V1_Preliminary Plan Drawings.pdf Markup Summary

PRAIRIE RIDGE FILING

Remove "opt" from all Type A & B c&g labels  
REVISED

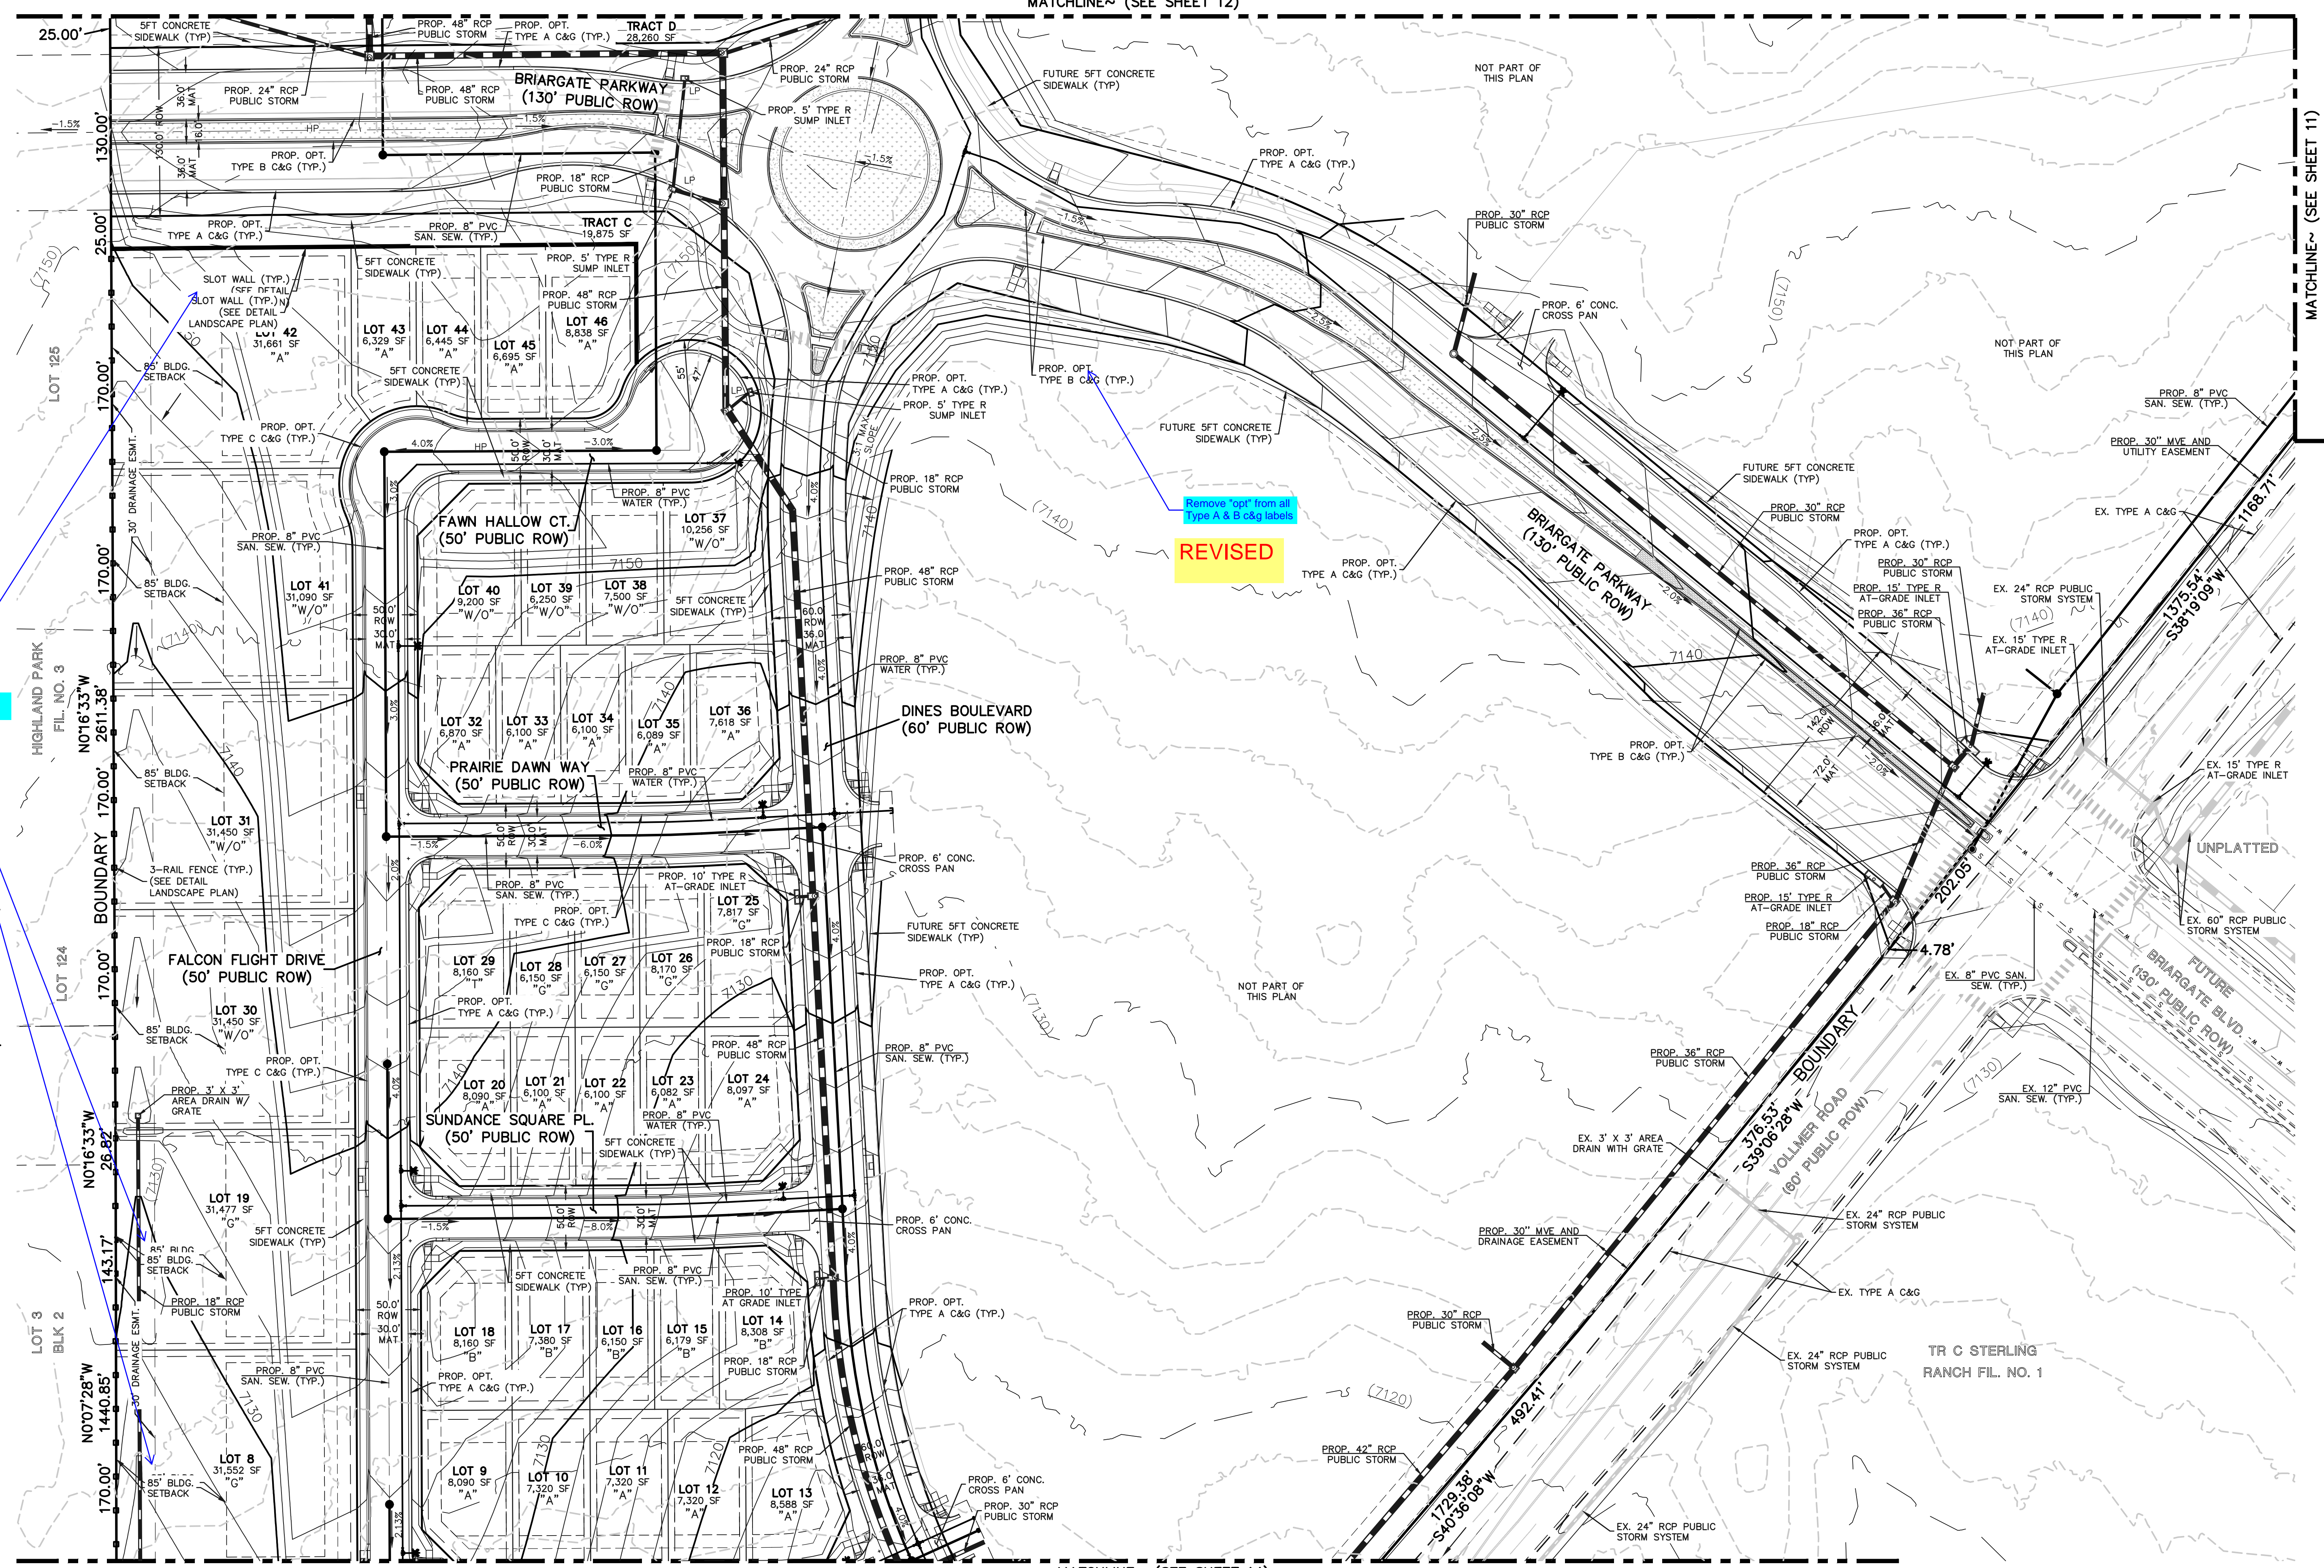
Double notes. Please delete one set

Remove "opt" from all Type A & B c&g labels

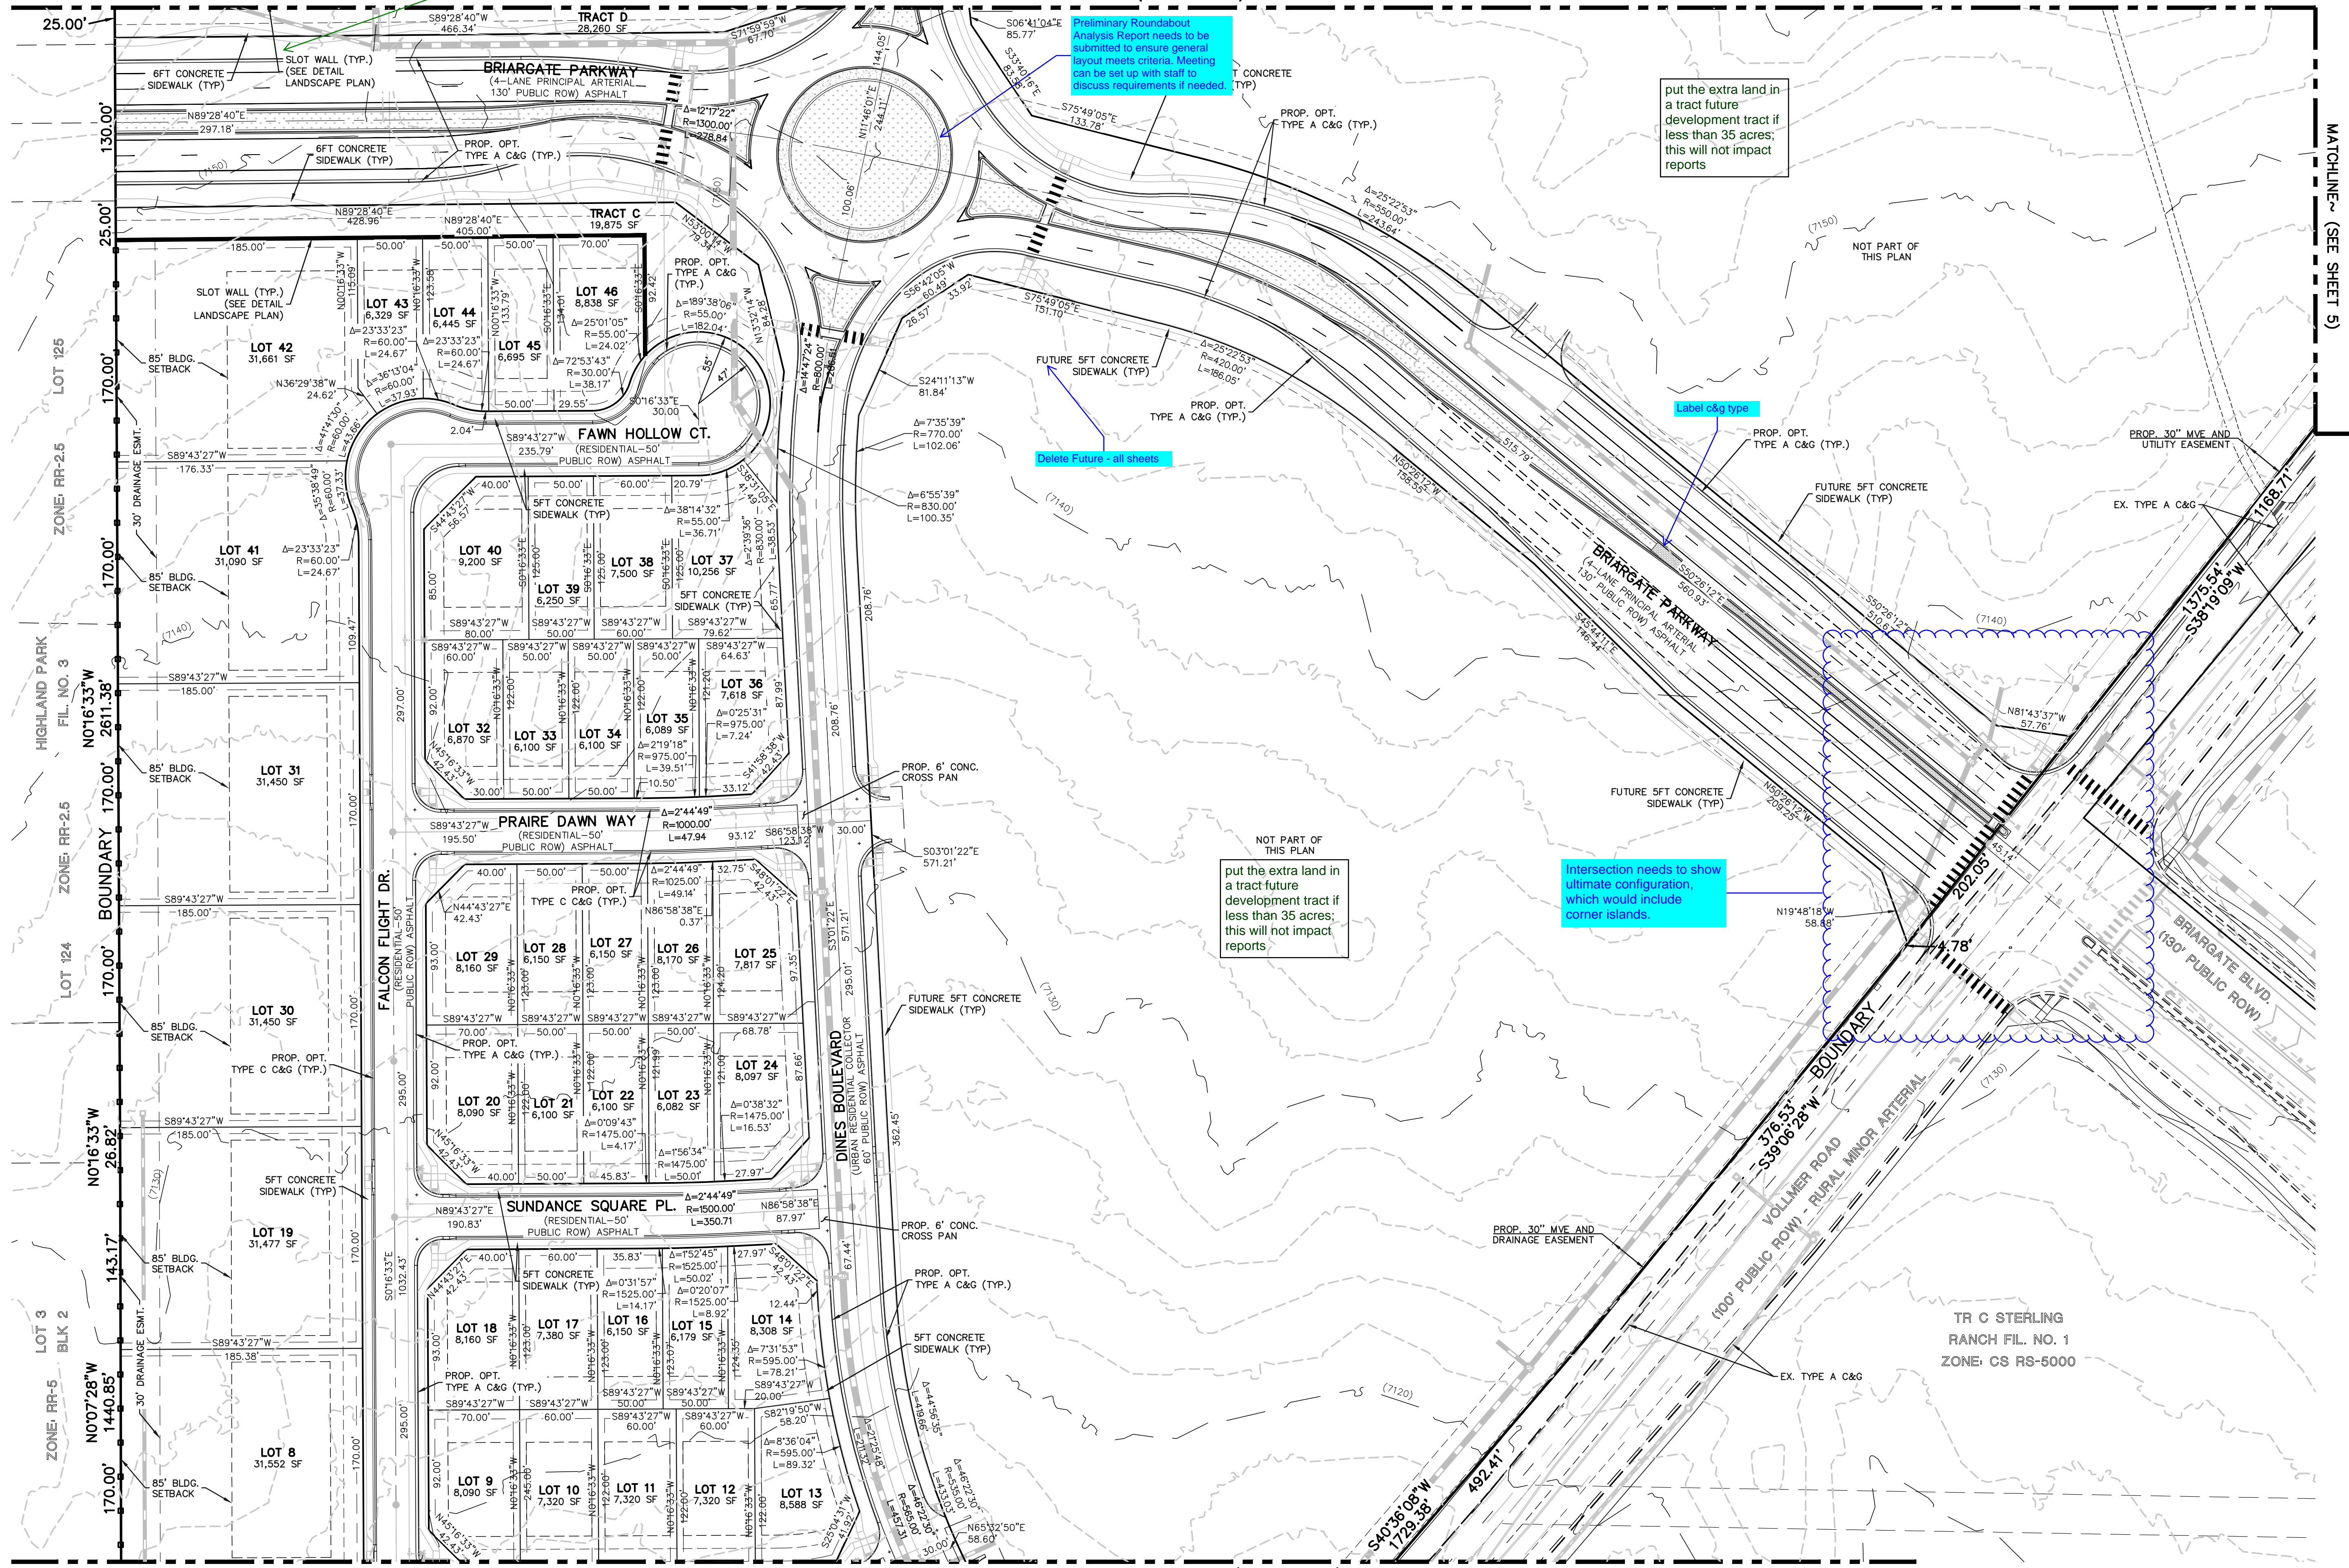
we cant leave off sliver of land less than 35 acres it would be an illegal parcel. add this to be FUTURE DEVELOPMENT tract or Park

Delete Future - all sheets
